SITE PLAN MAP 44/BLOCK A/LOTS 29 & 31

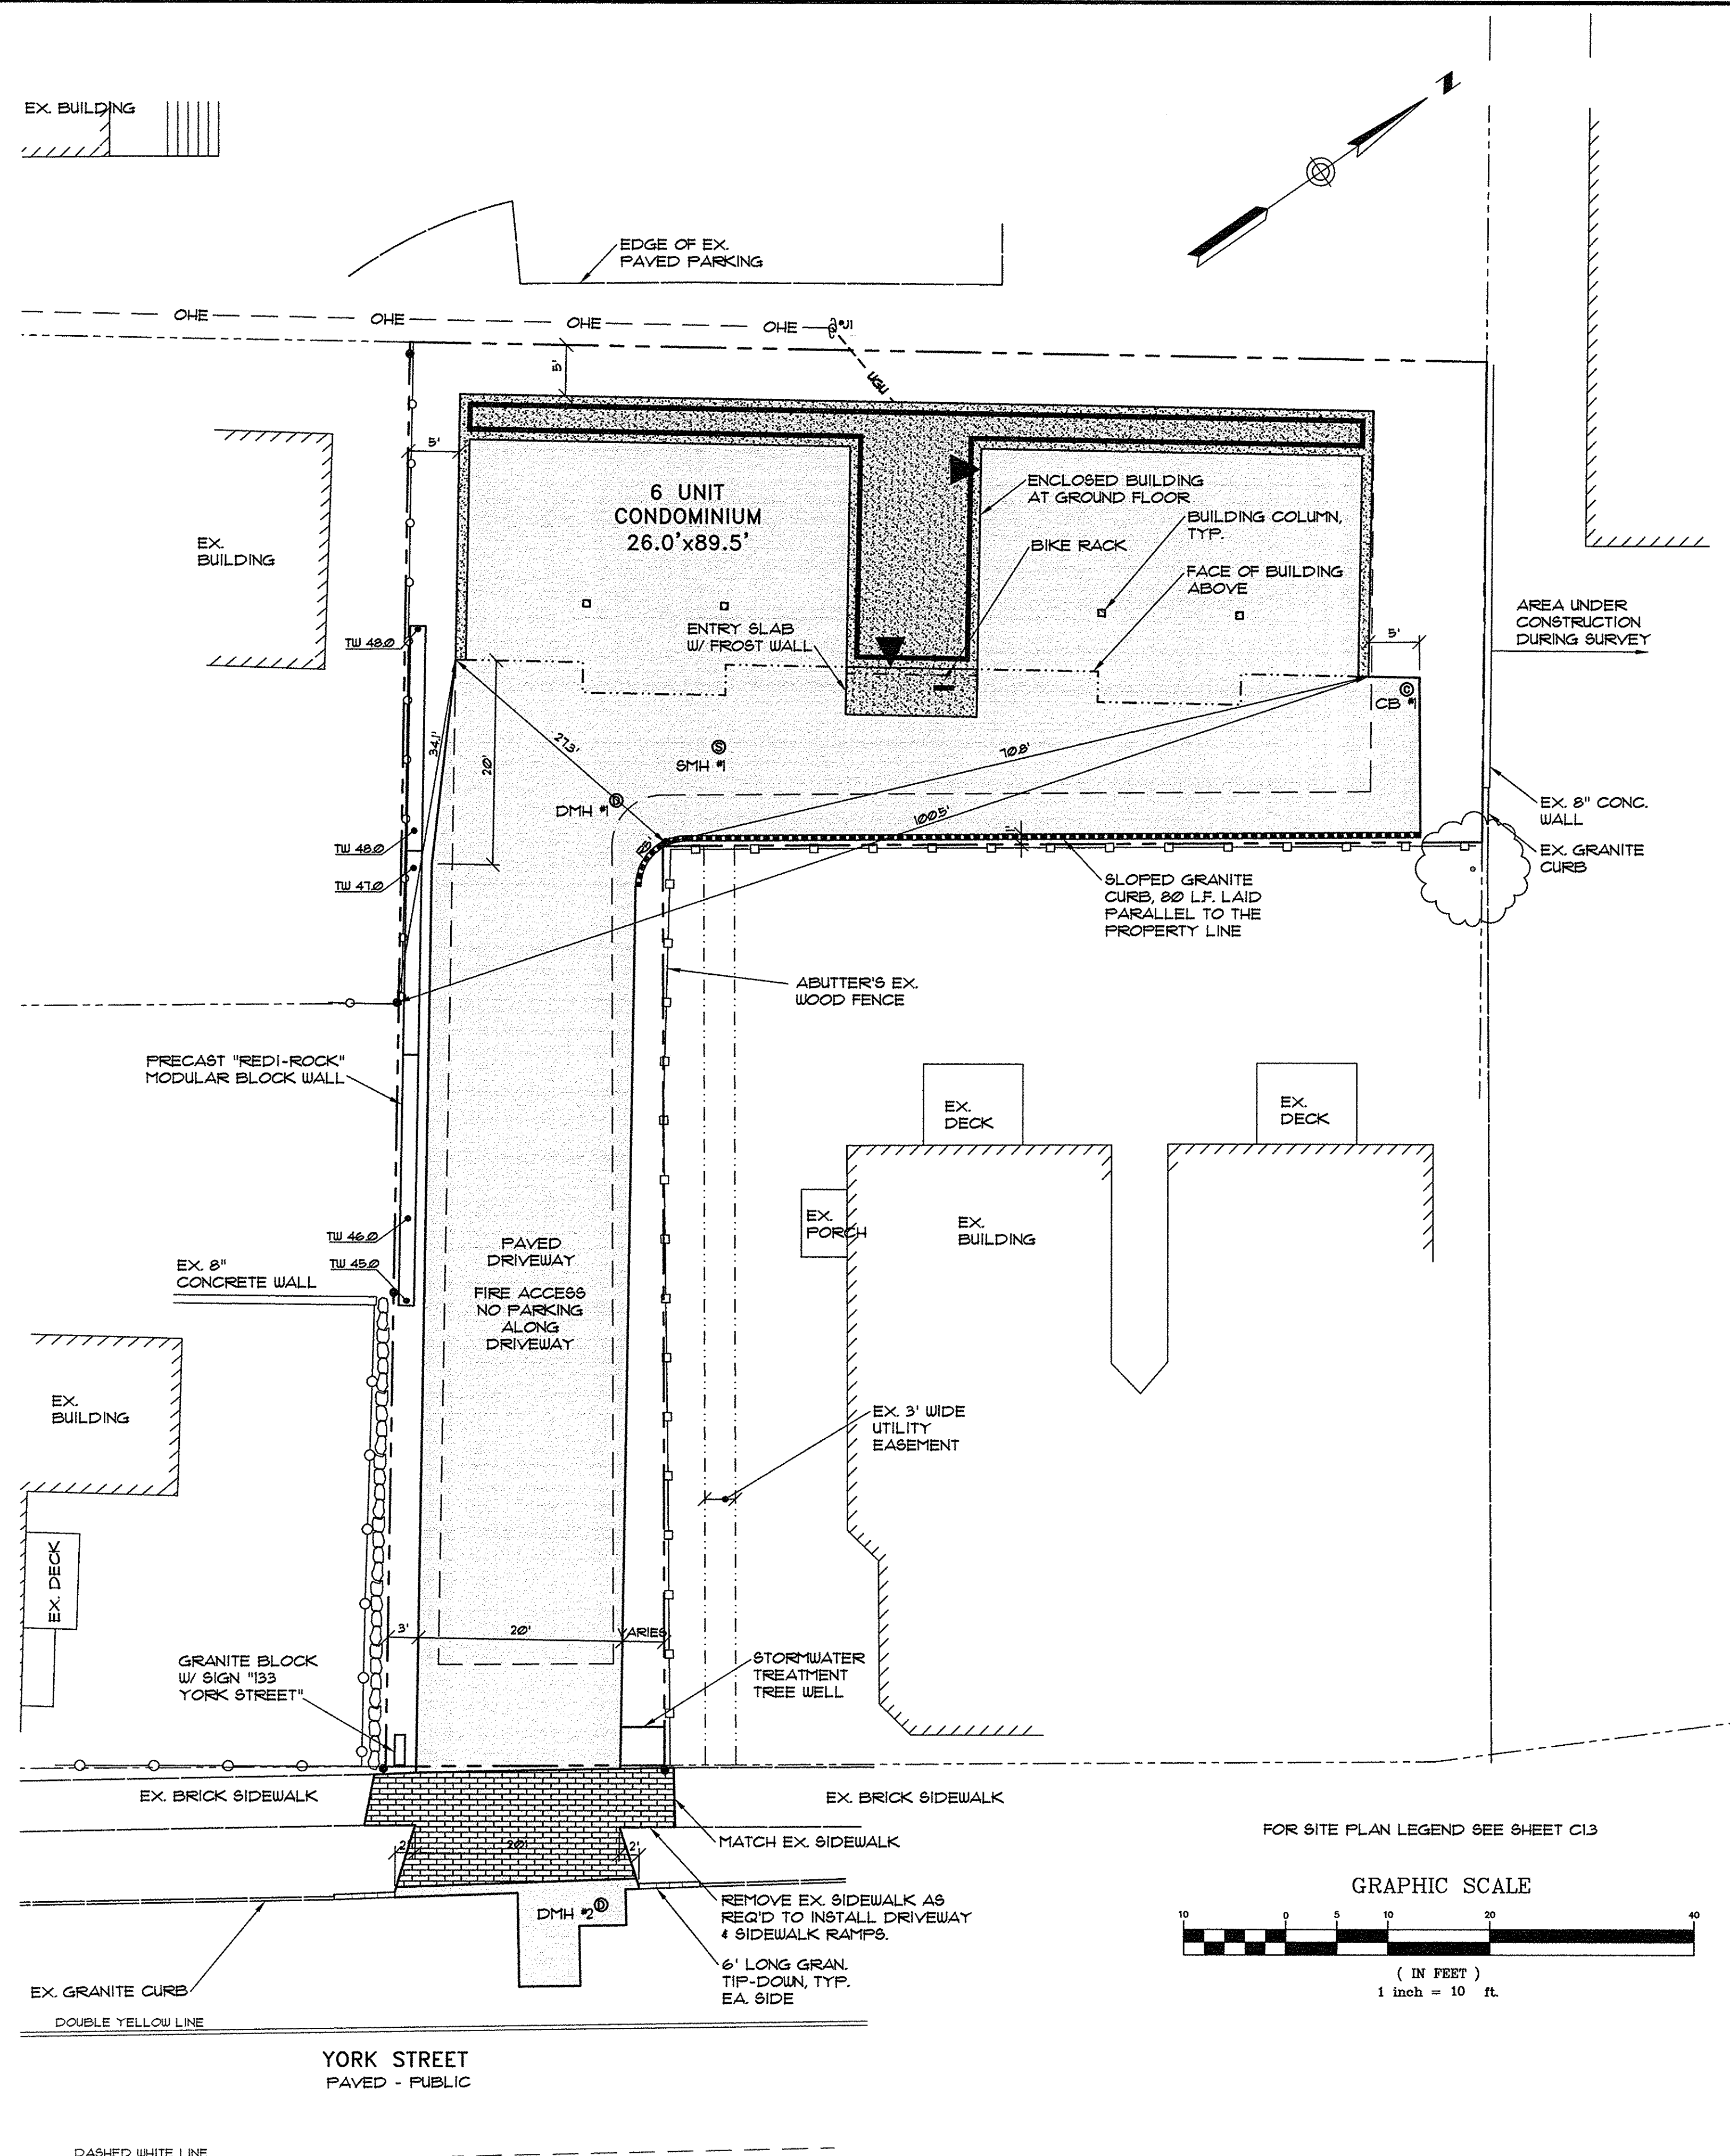
3. Headlights from underground parking area will shine directly into the windows of the rear Flats first floor residences

4. The water abatement plan is of serious concern given the present volume of runoff into the Flats basement

The third issue was runoff and Tom said that there would be a catch basin on the 133 side opposite the Willow tree, which was good but that the only other consideration would be a 6" curb running from the catch basin to where the driveway would be. It was pointed out by myself and several others in attendance that the land as it stands now absorbs a lot of the water but that the new building roof and the paving for driveway would overwhelm any "standard" effort like a 6" curb. It was pointed out that we expected no negative impact upon the Flats basement from this new project.

EROSION CONTROL AND LANDSCAPE PLAN

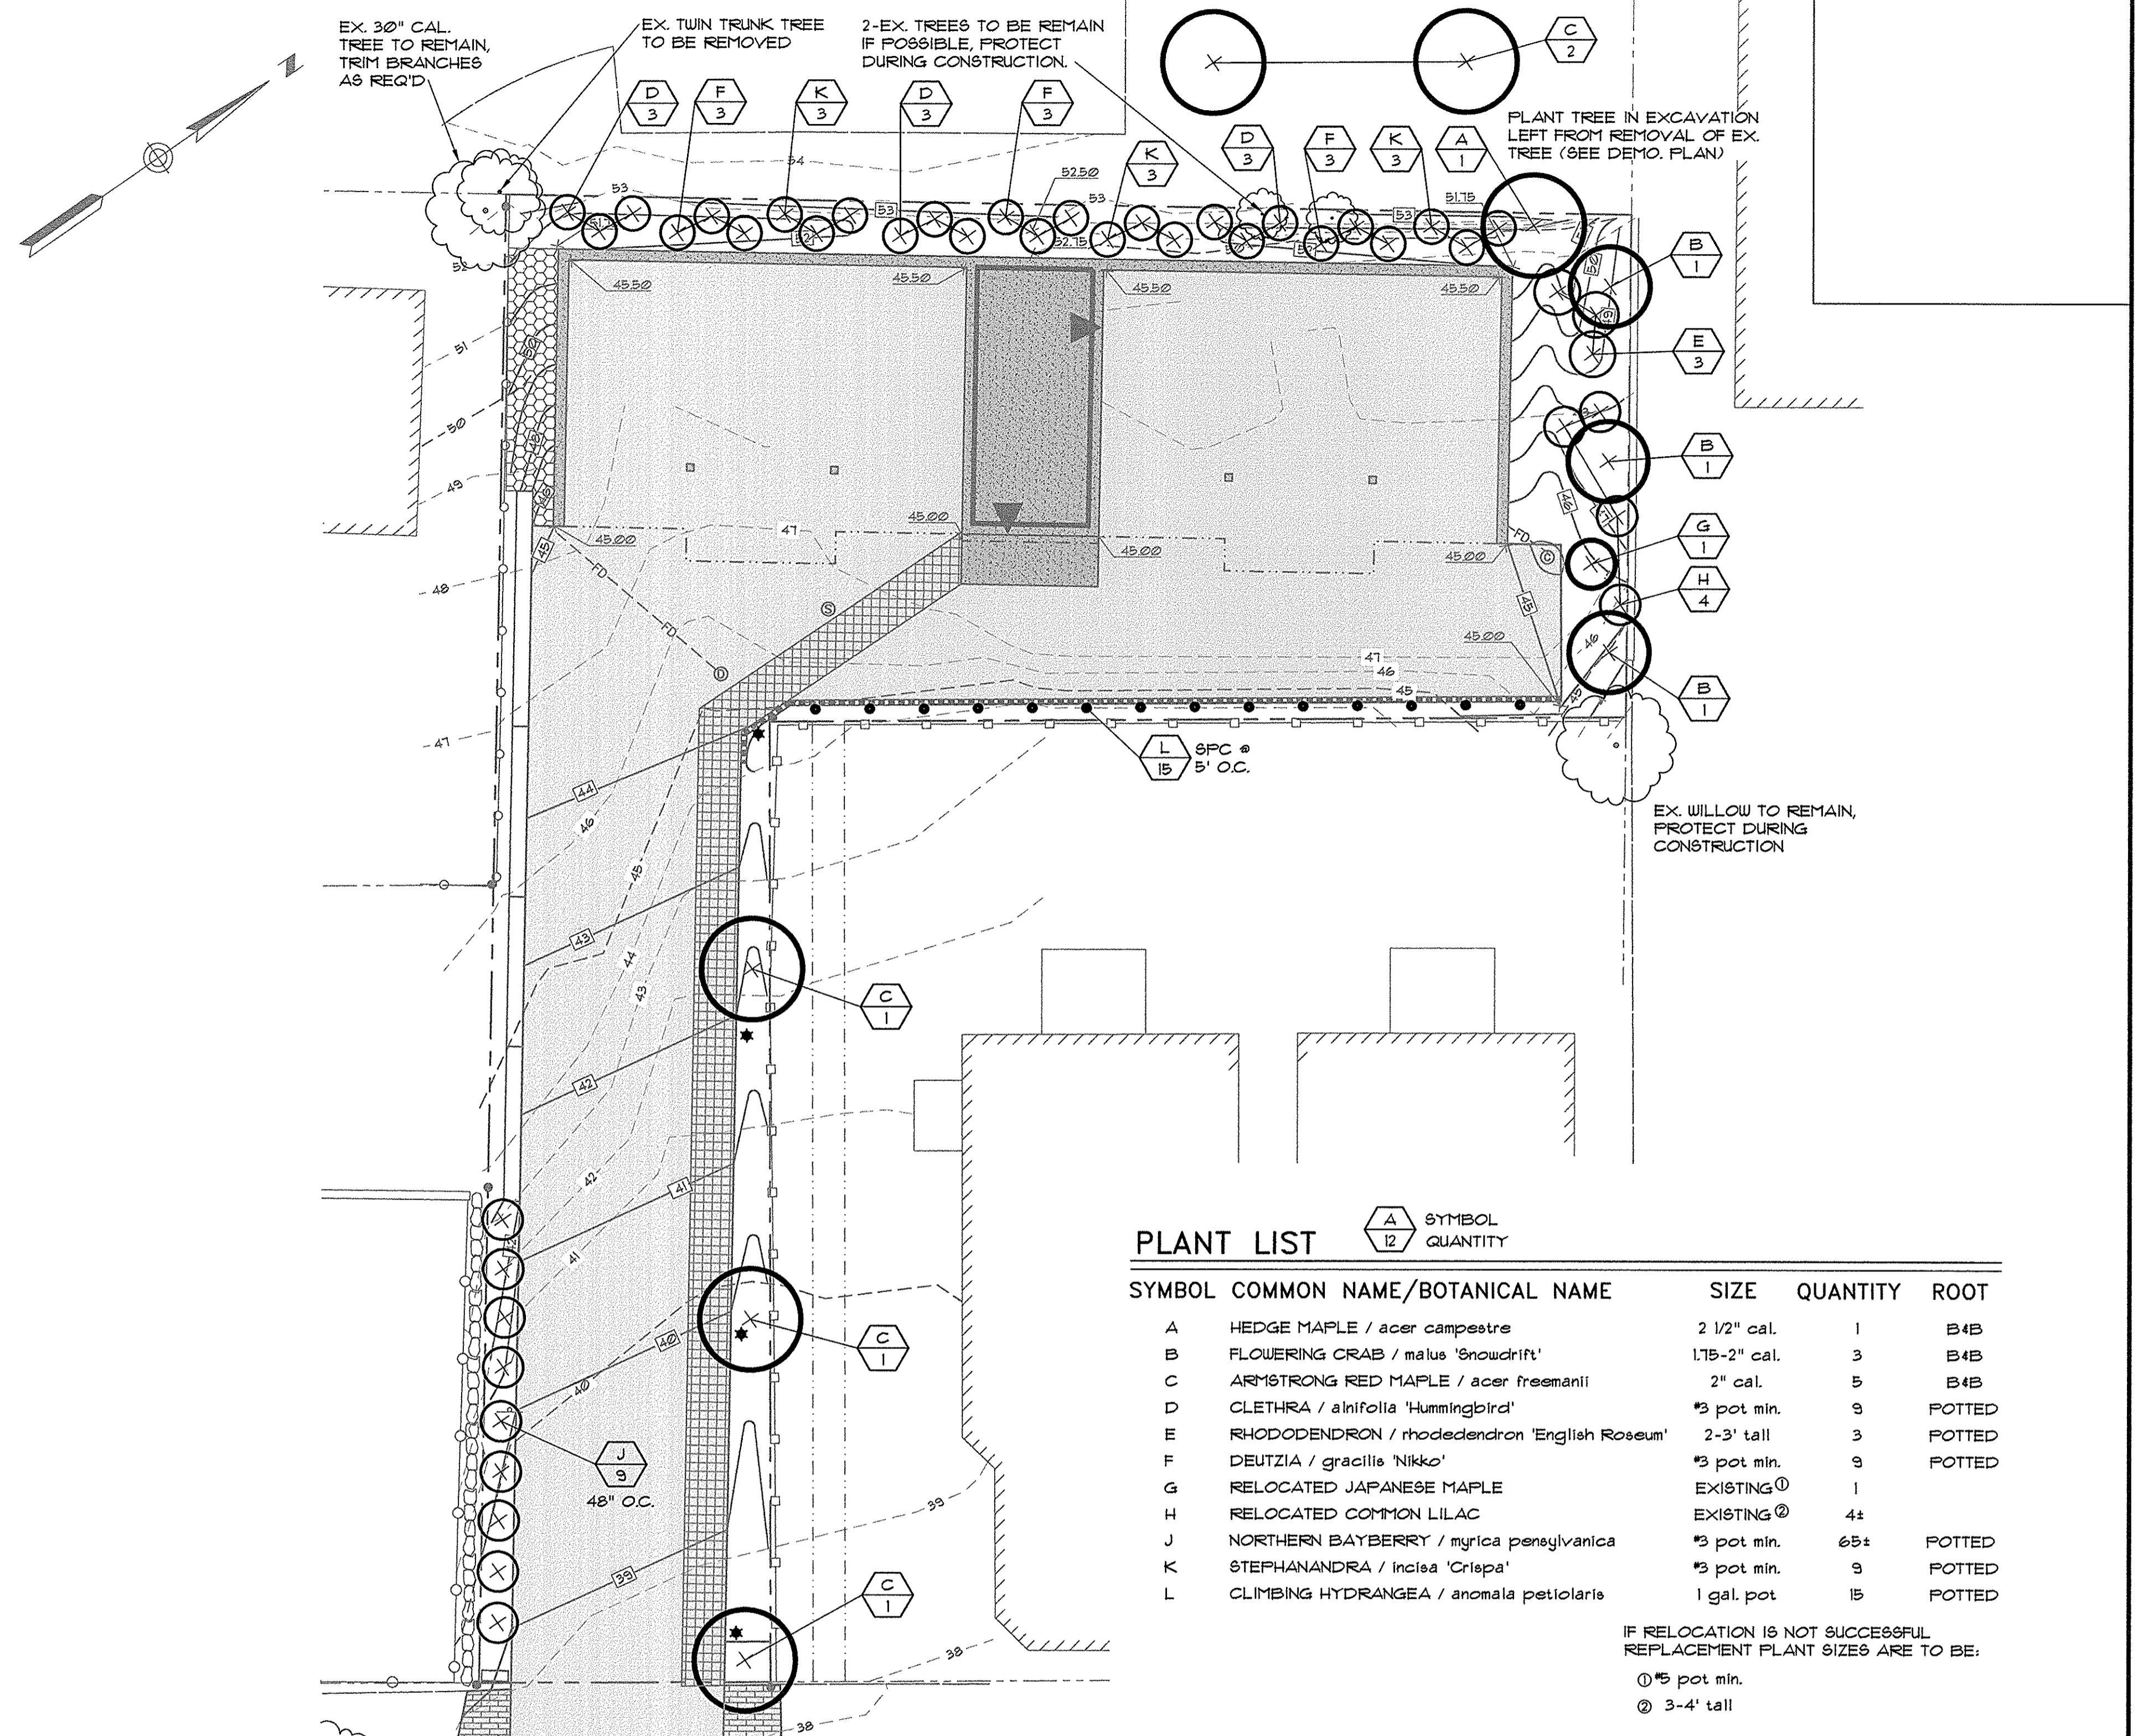
Tom said that the large tree on their property that stands near the fence beside Unit A in the "T'Homes" building probably could not be saved. He said that the builder thought it too close to the new building and that a large section would have to go. The remaining portion would be "unsafe" and should be taken down as well. He offered two new, much smaller, trees in its stead. I asked how close the new building would be to the property line. He said "13 feet". I pointed out that this was at least 15 feet different than what was described at the first meeting. He denied it. I told him how he had described it to me at the first meeting. "At the far side of the shed." It was now a good distance beyond the far side of the shed. As described at the first meeting I did not see a difficulty in keeping the tree.
